**City of Portland, Maine - Building or Use Permit Application**  
 389 Congress Street, 04101 Tel: (207) 874-8703, Fax: (207) 874-8716

<b>Permit No:</b> 06-1425	<b>Issue Date:</b>	<b>CBL:</b> 406 F052001
------------------------------	--------------------	----------------------------

<b>Location of Construction:</b> 9 STEPPING STONE LN #2	<b>Owner Name:</b> KING CONSTRUCTION CORP	<b>Owner Address:</b> 198 SACO AVE	<b>Phone:</b>
<b>Business Name:</b>	<b>Contractor Name:</b> King Construction Corp	<b>Contractor Address:</b> 198 Saco OOB	<b>Phone</b> 2079347622
<b>Lessee/Buyer's Name</b>	<b>Phone:</b>	<b>Permit Type:</b> Single Family	<b>Zone:</b>

**Dept:** Building      **Status:** Approved with Conditions      **Reviewer:** Tammy Munson      **Approval Date:** 01/12/2007

ELEVATIONS / ROOF PLAN
THE BREWSTER

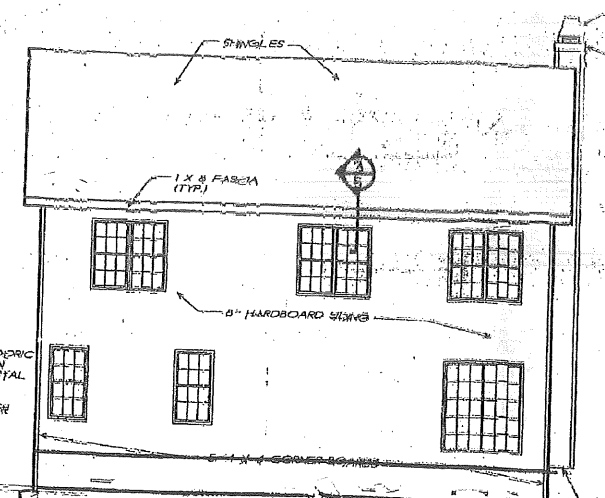
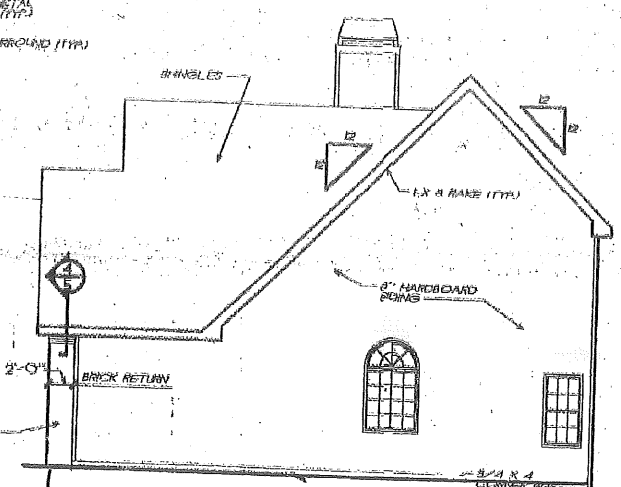
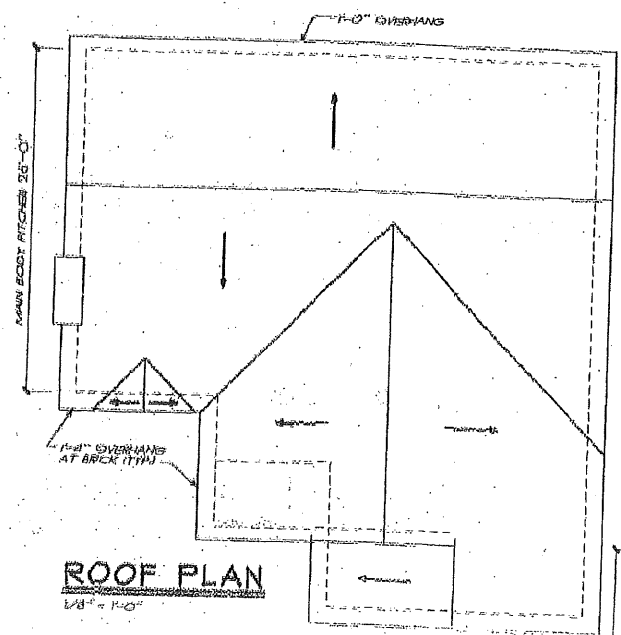
10/4/2006-amachado: Elevation plans show daylight basement in rear. Grading on site plan does not match. Left message for King Weinstein to call me.

2ND FLOOR FRAMING PLAN
THE BREWSTER

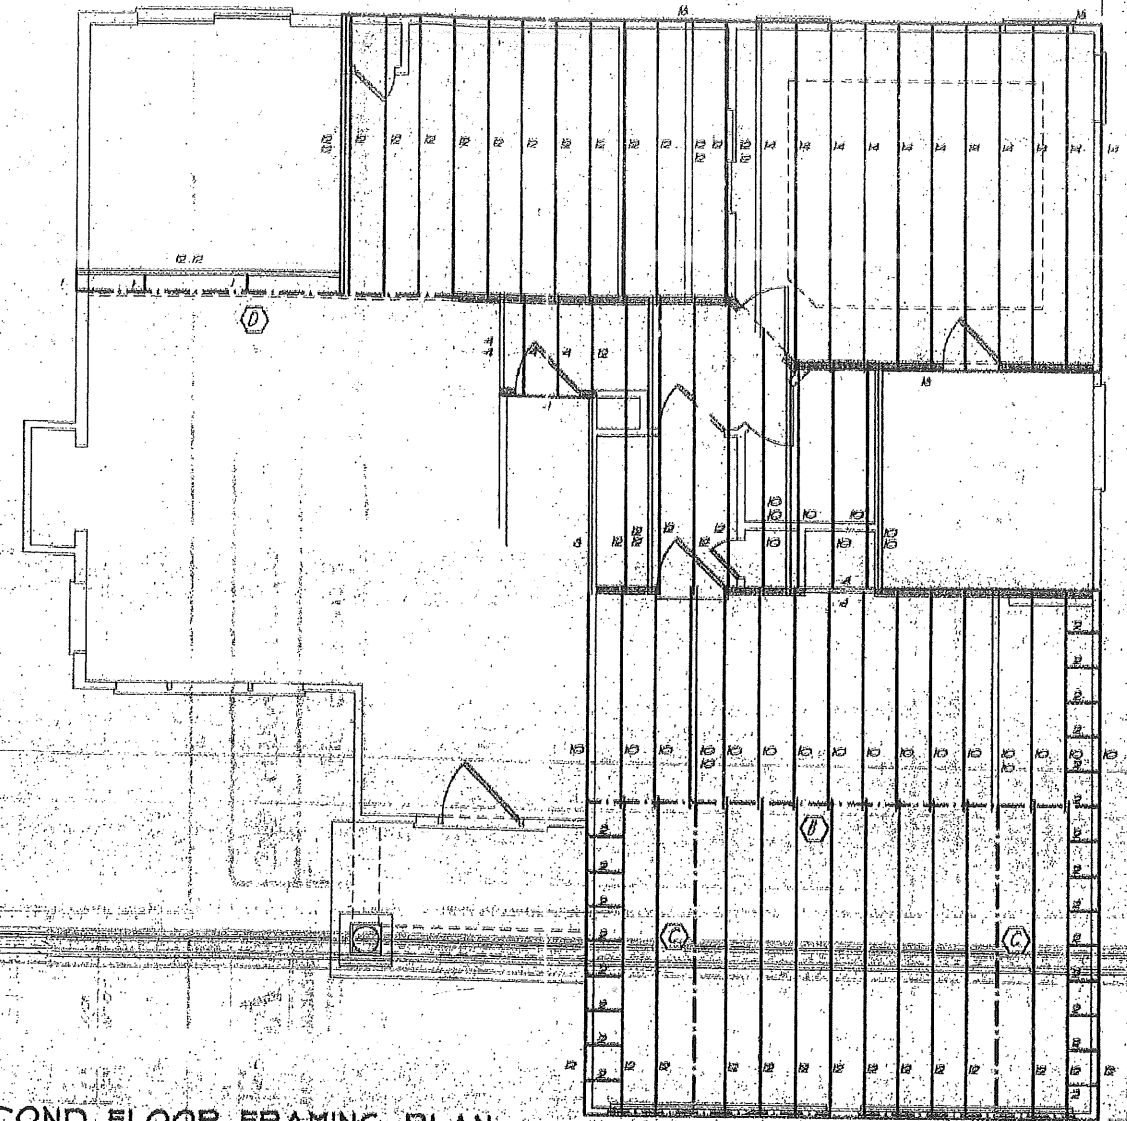
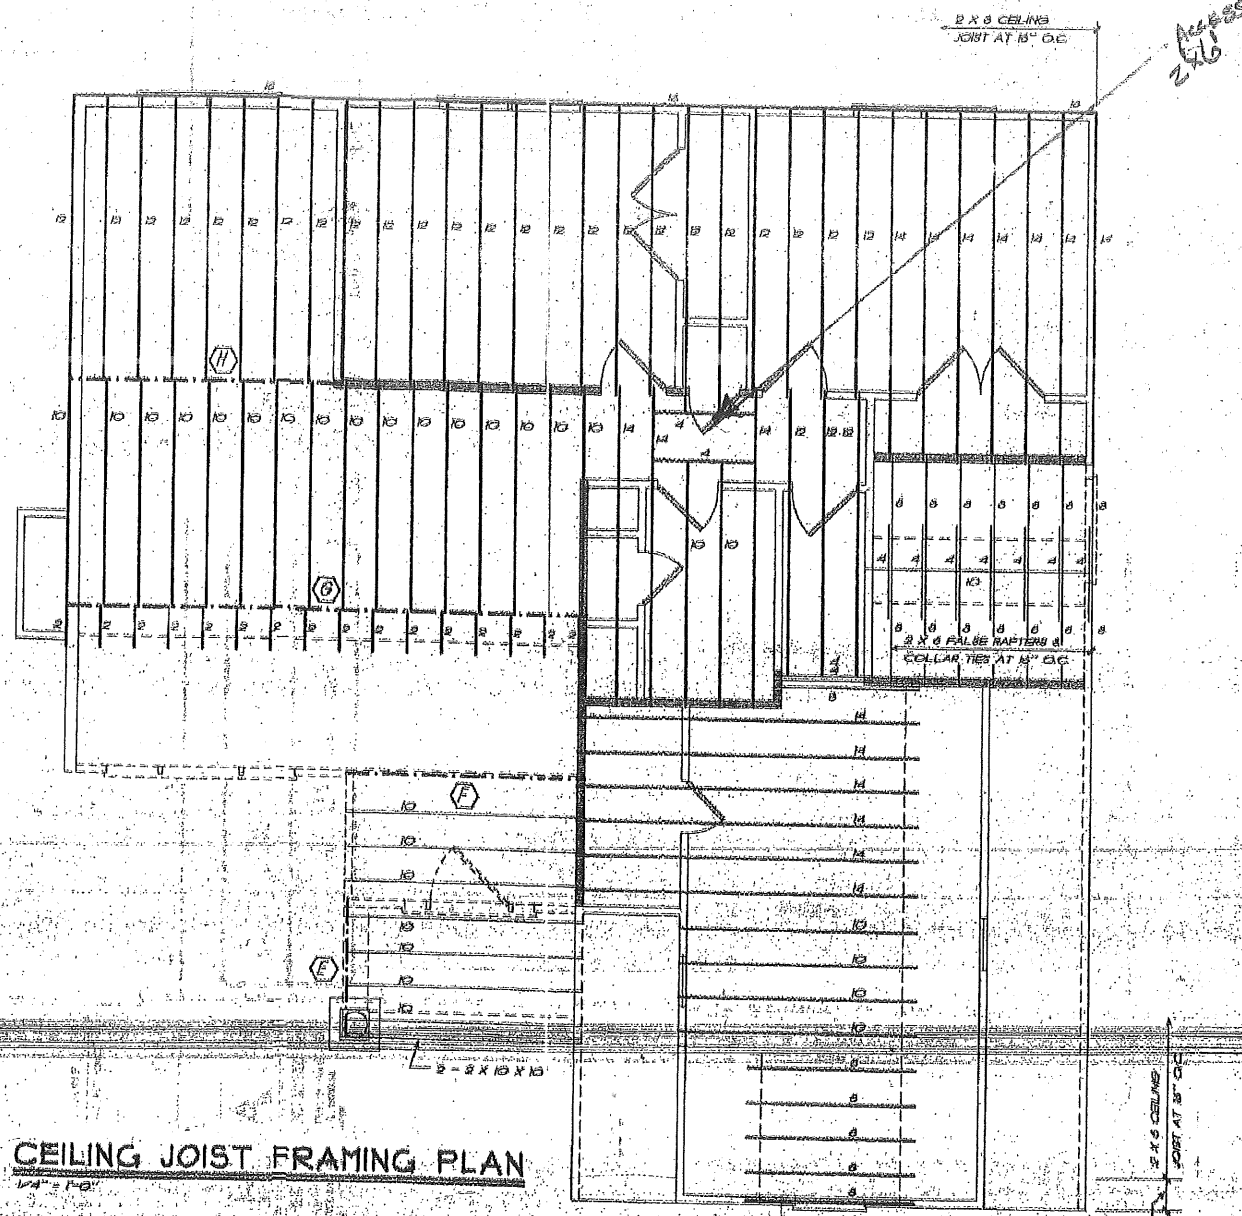
- 2) The basement is NOT approved as habitable space. A code compliant 2nd means of egress must be installed in order to change the use of this space.
- 3) The design load spec sheets for any engineered beam(s) must be submitted to this office.

2 X 8 RAFTERS
AT 18" OC

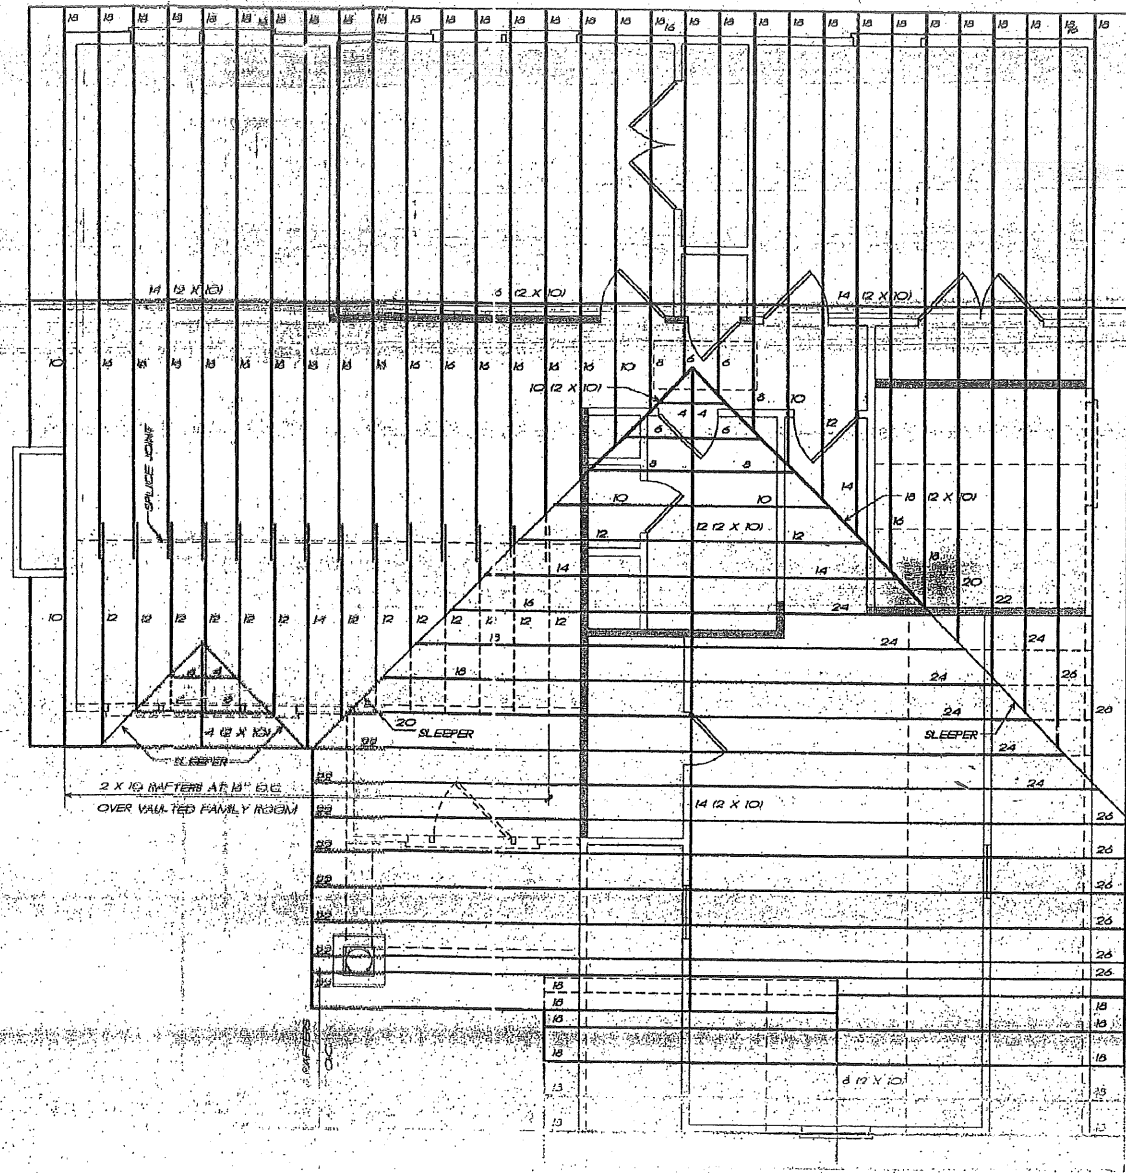
- 4) Permit approved based on the plans submitted and reviewed w/owner/contractor, with additional information as agreed on and as noted on plans.
- 5) As discussed, the rafters must be 2" x 10"s.
